May 15, 2008

**Re: Status of Improvement Permit Application #08-5-20035  
Persimmon Lt 56**

Lot 56 Persimmon Hill

S & K HOMES  
THE CAPE

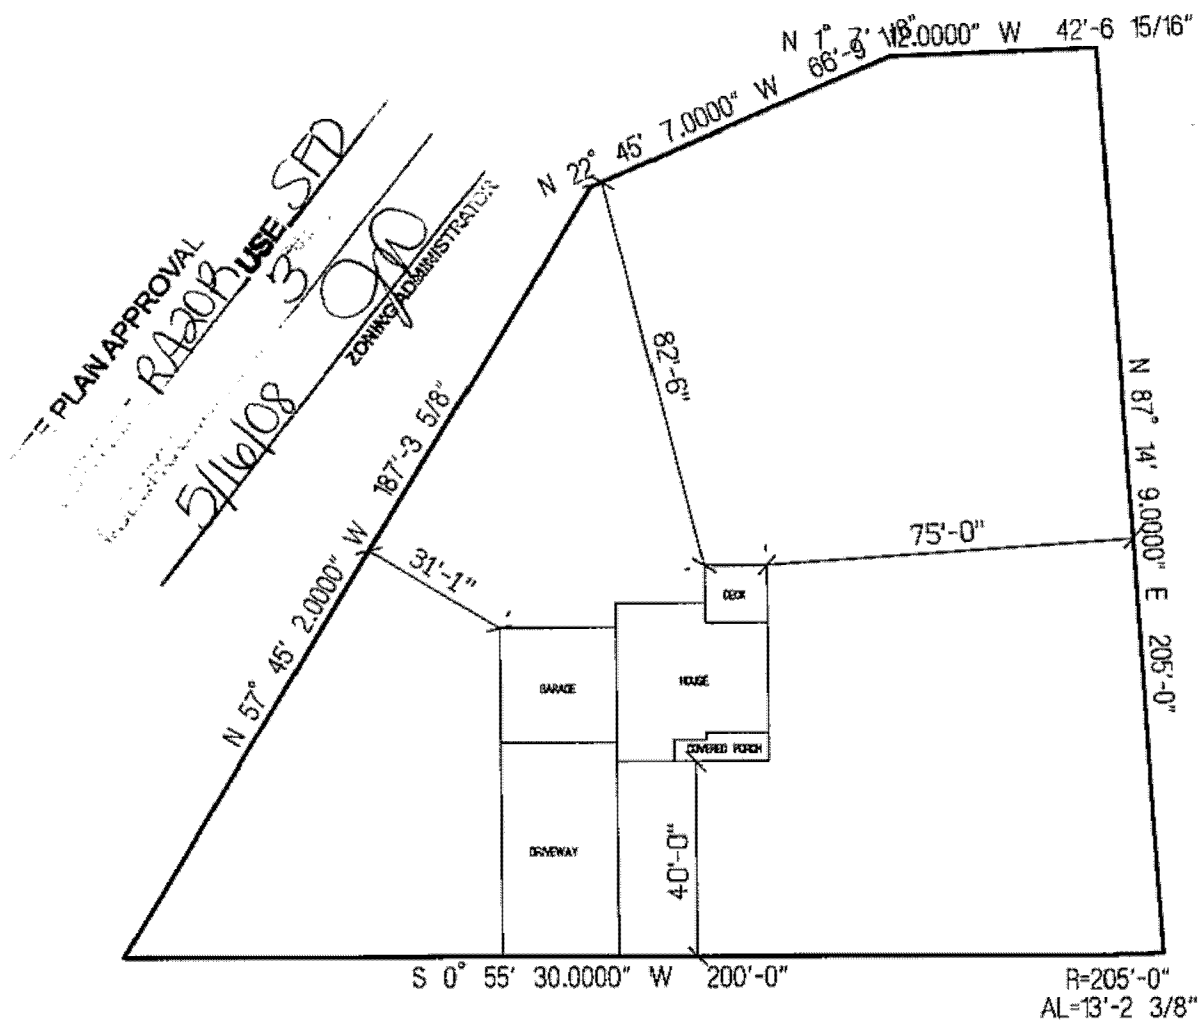
- 1. Property lines/corners not marked or labeled
- 2. House corners not marked or labeled
- 3. Directions not clear to property
- 4. Property needs brush or vegetation removed
- 5. Backhoe pits required
- 6. Other – Move house and drive as shown and submit new plot plan to Central Permitting.

Move house & Drive AS shown
